FULL

Reference: H16-0080-24 **Date of Decision:** 23rd May 2024
Applicant: Mr M S & Mrs T E Denton
30 Alexandra Road
Spalding
Lincolnshire
PE11 2PX
Location: 30 Alexandra Road Spalding
Description: Proposed Extensions and Alterations

Proposed East & West Elevations

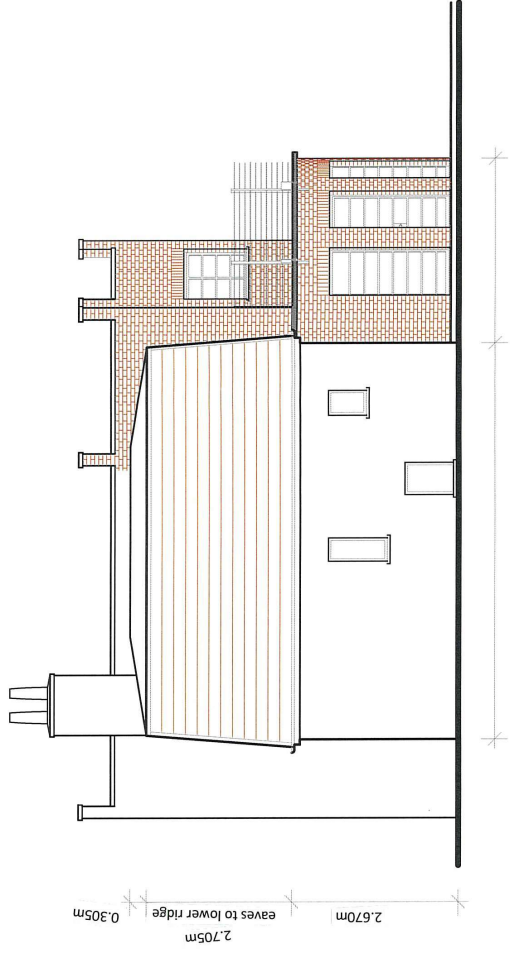
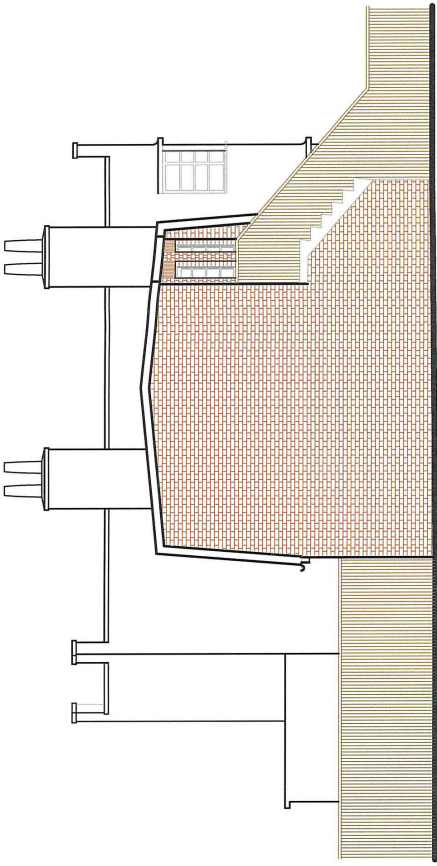
- 1 The proposed mansard extension by virtue of its scale, appearance and general design would give rise to an unacceptable impact upon the character of the surrounding area, including Alexandra Road. The proposed mansard extension would represent an extraneous feature, which is poorly integrated into the host dwelling and the wider street scene. The proposal fails to conform with Section 12 of the National Planning Policy Framework (December 2023), and therefore, it is considered that the proposal is inappropriate.

- 2 The proposed extensions, by virtue of their height and siting, would result in an unacceptable impact to the amenities of neighbouring occupiers, including through overlooking and overshadowing the gardens of both adjacent neighbours. This would significantly reduce the sunlight reaching the garden and therefore would reduce the quality of life of the occupiers.
